Rezoning Transportation Analysis

Petition Number: 2025-091

| Date | Description |
|----------|-------------------|
| 08-28-25 | First Review (CM) |

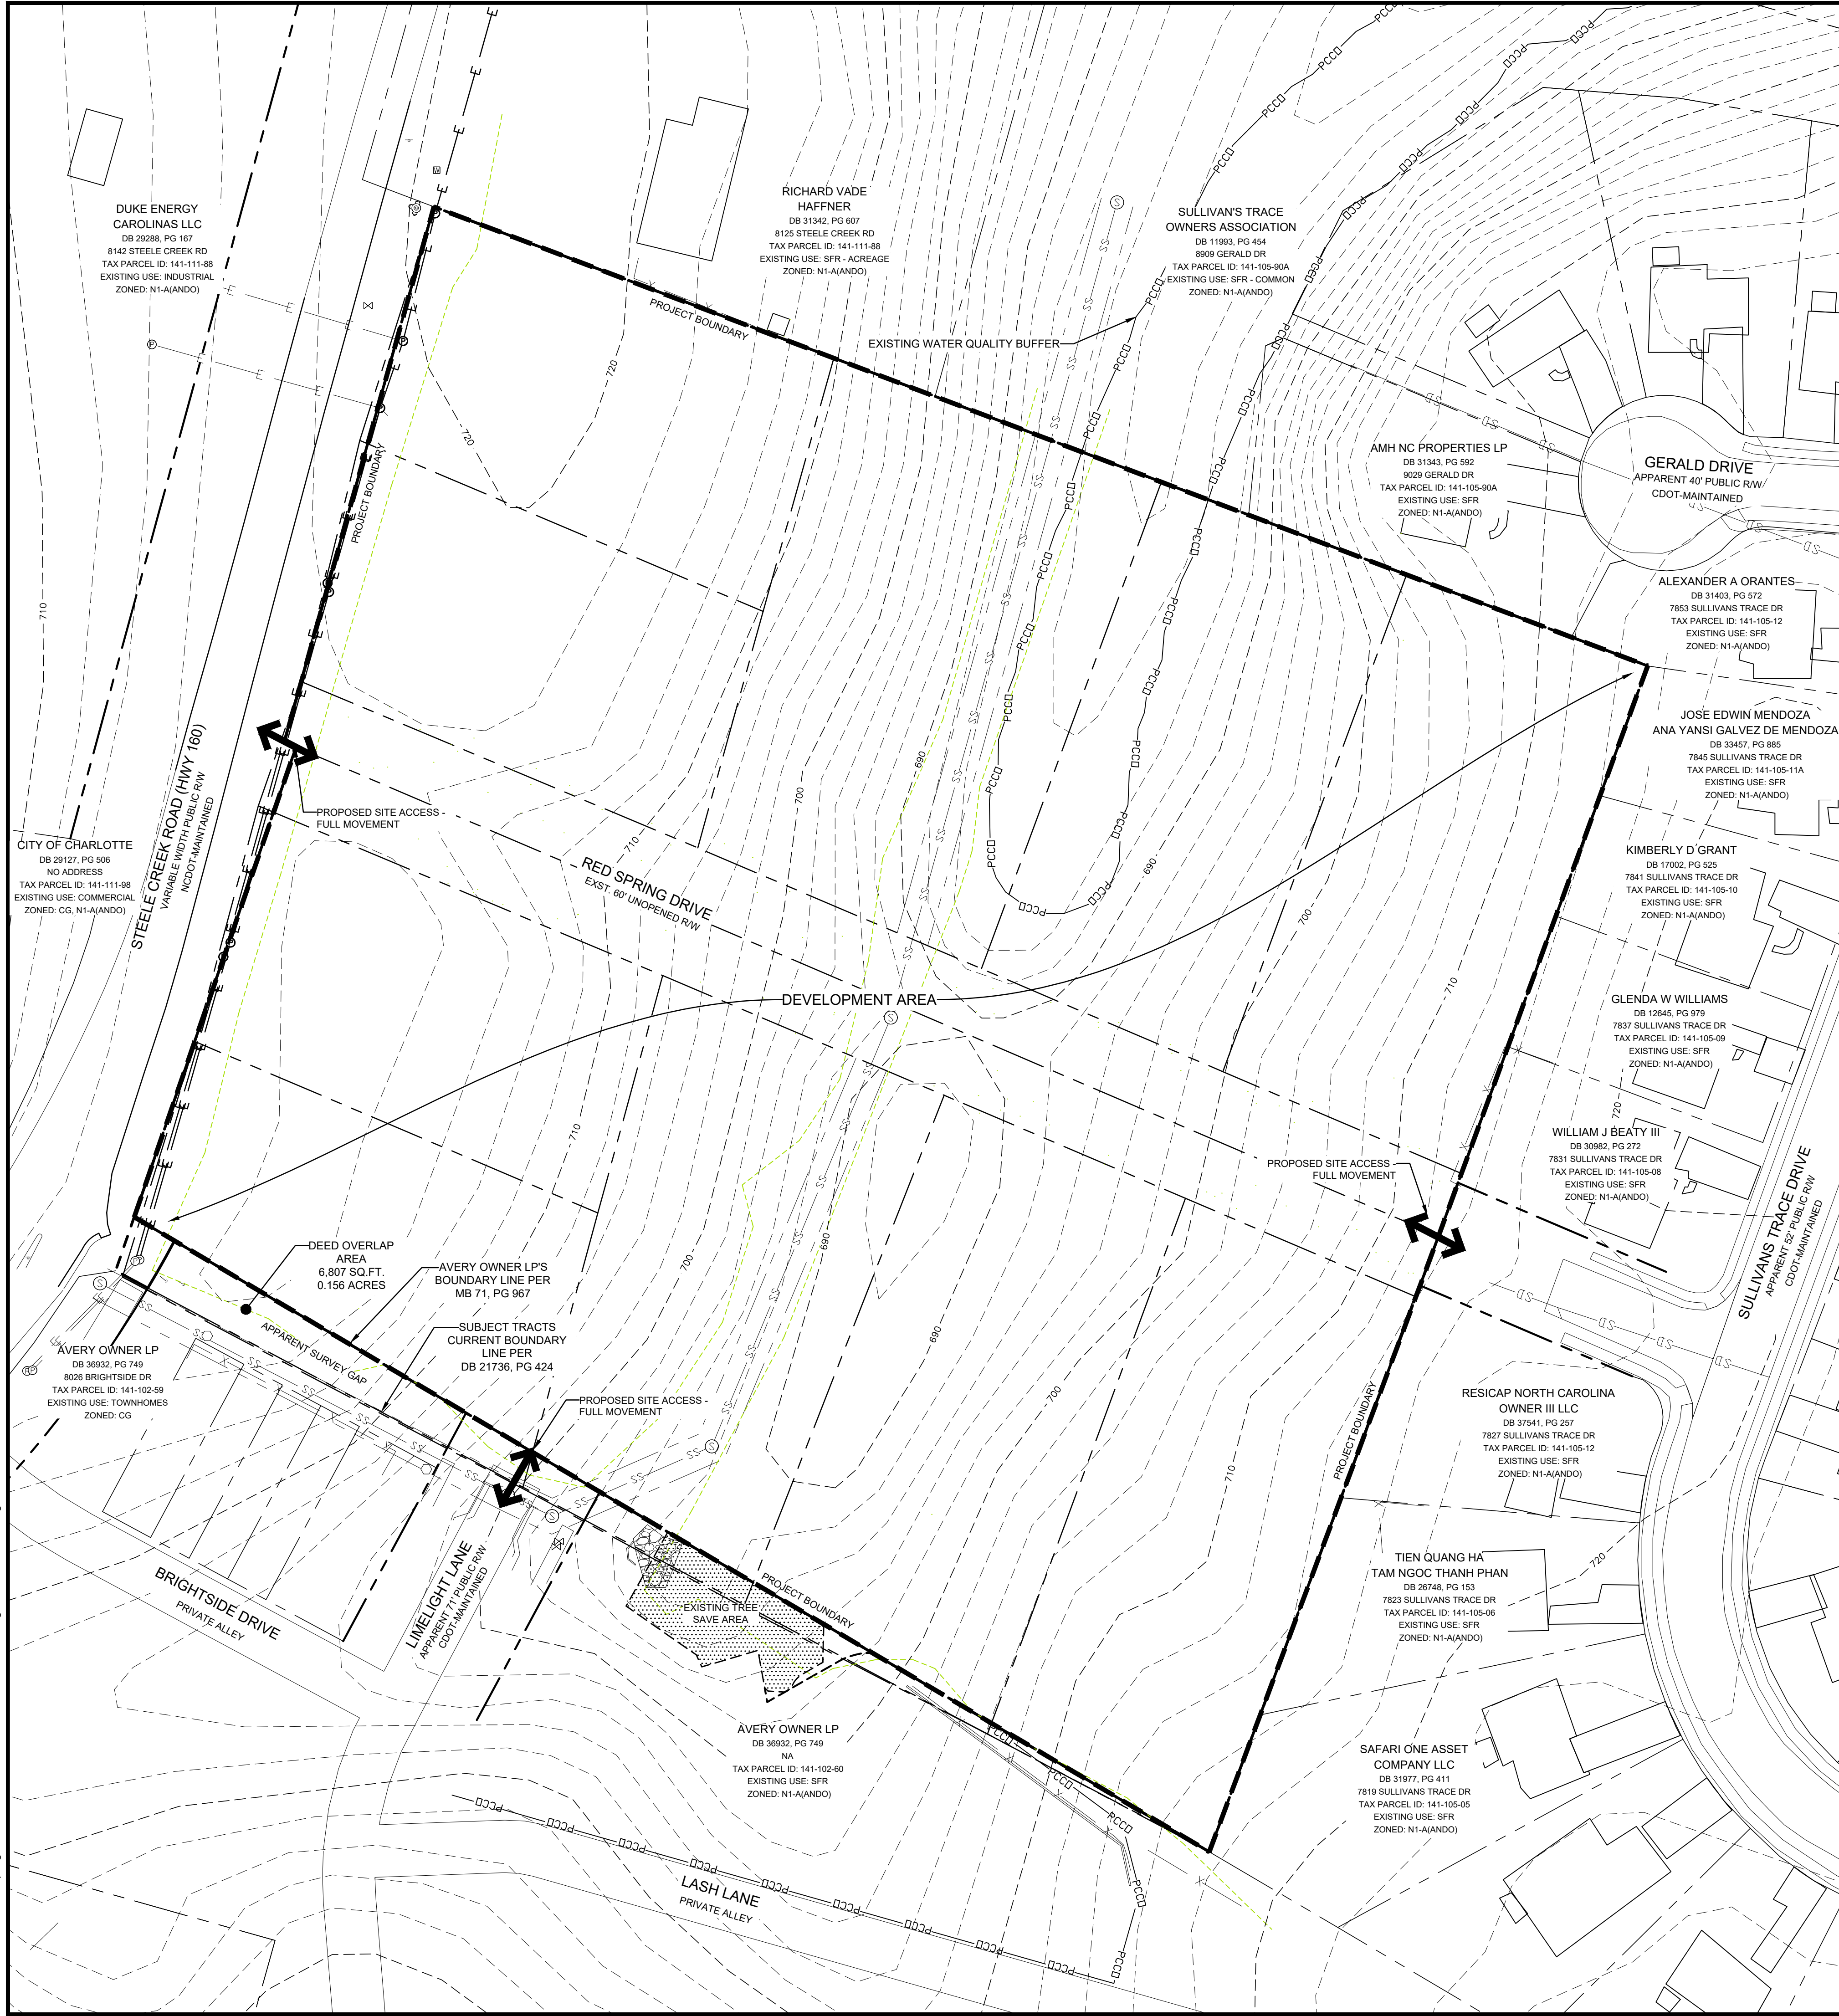
Steele Creek Road: The future location of the back of curb and gutter is minimum 38ft from roadway centerline to accommodate a 4+ Avenue, Buffered/Separated Bike Lanes per Charlotte Streets Map.

- a. Limelight Lane: The future location of the back of curb and gutter is minimum 17.5' from roadway centerline following CLDSM U-03A1 detail.

- b. Red Spring Drive: The future location of the back of curb and gutter is minimum 17.5-feet from roadway centerline following CLDSM U-03A1 detail.

Label and dimension the curb and gutter from the centerline for each road on the site plan.

- Revise site plan and conditional note(s) to commit to dedicate minimum 54-feet right-of-way from the road centerline along Steele Creek Road. The site plan shall label and dimension the right-of-way from the road centerline.
- Revise site plan and conditional note(s) to commit to construct bicycle facilities by locating the curb and gutter a minimum 38-feet from the roadway centerline along Steele Creek Road.
- Revise site plan and conditional note(s) to commit to installing a right-turn lane and left-turn lane into the access on Steele Creek Road. Coordinate with NCDOT to determine storage lengths and taper lengths.
- Revise site plan and conditional note(s) to provide a minimum 100-ft protected stem from Steele Creek Road measured from the Right-of-way.
- Revise site plan and conditional note(s) to connect sidewalk to existing sidewalk along Steele Creek Road to the south.
